Your ref:	Planning Flat D - W2 4PL	Please reply to:	Fraser Fikrie
Our ref:	23/07456/FULL	Tel No:	0753424 7967
		Fee Queries:	0207 641 6500;
		Email:	planningreception@westminster.gov.uk;
Frederic & Anastasiia Noiroi-Nerin 2 Leinster Square Flat D London City Of Westminster W2 4PL United Kingdom		Incomplete Applications Town Planning & Building Control City of Westminster PO Box 732 Redhill, RH1 9FL	
		3 November 2023

Address: Flat D, 2 Leinster Square, London, W2 4PL,

Proposal: Replacement of all windows (3 on the front and 2 in the rear) at third floor level with double-glazed timber windows and internal works. (Linked with 23/07457/LBC)

| Title<br>PLANS: EXISTING + PROPOSED                                | Drawn by<br>NJB |

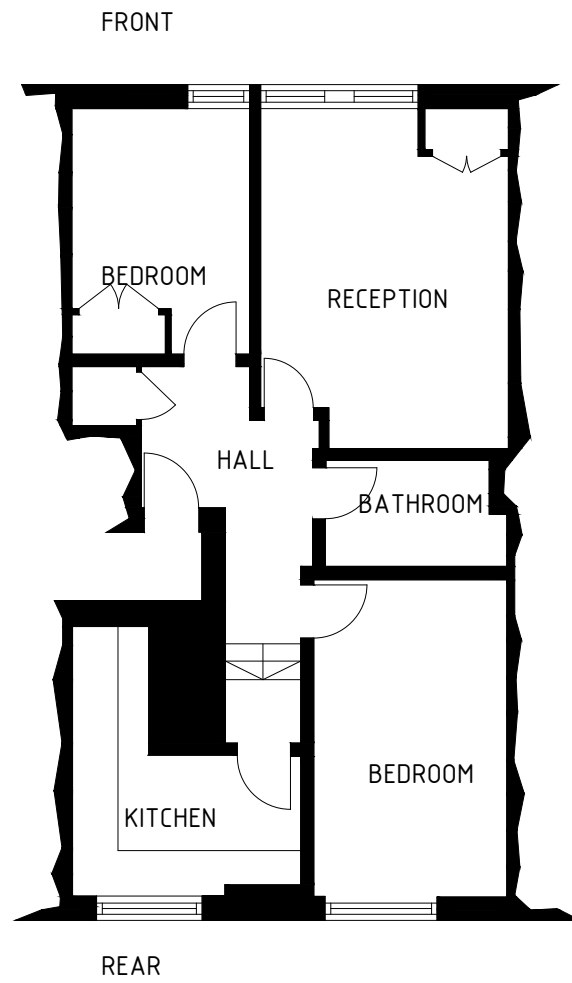
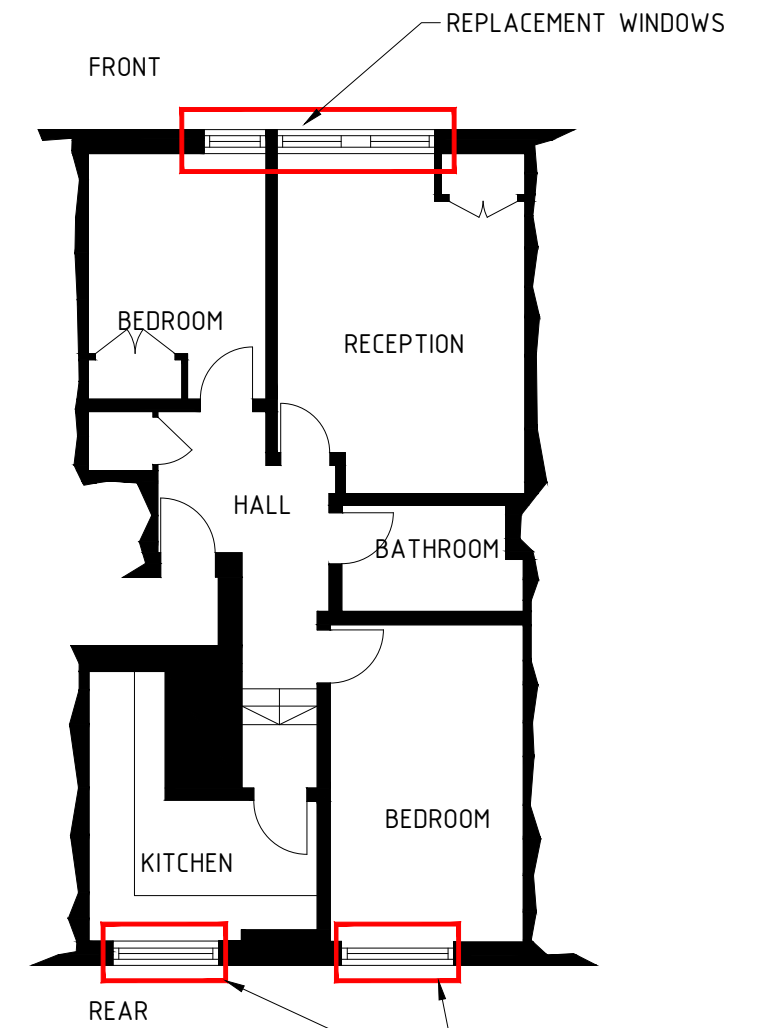
1 The floor plans you have provided are not labelled as either existing or proposed. Please revise your plans to include correct labelling
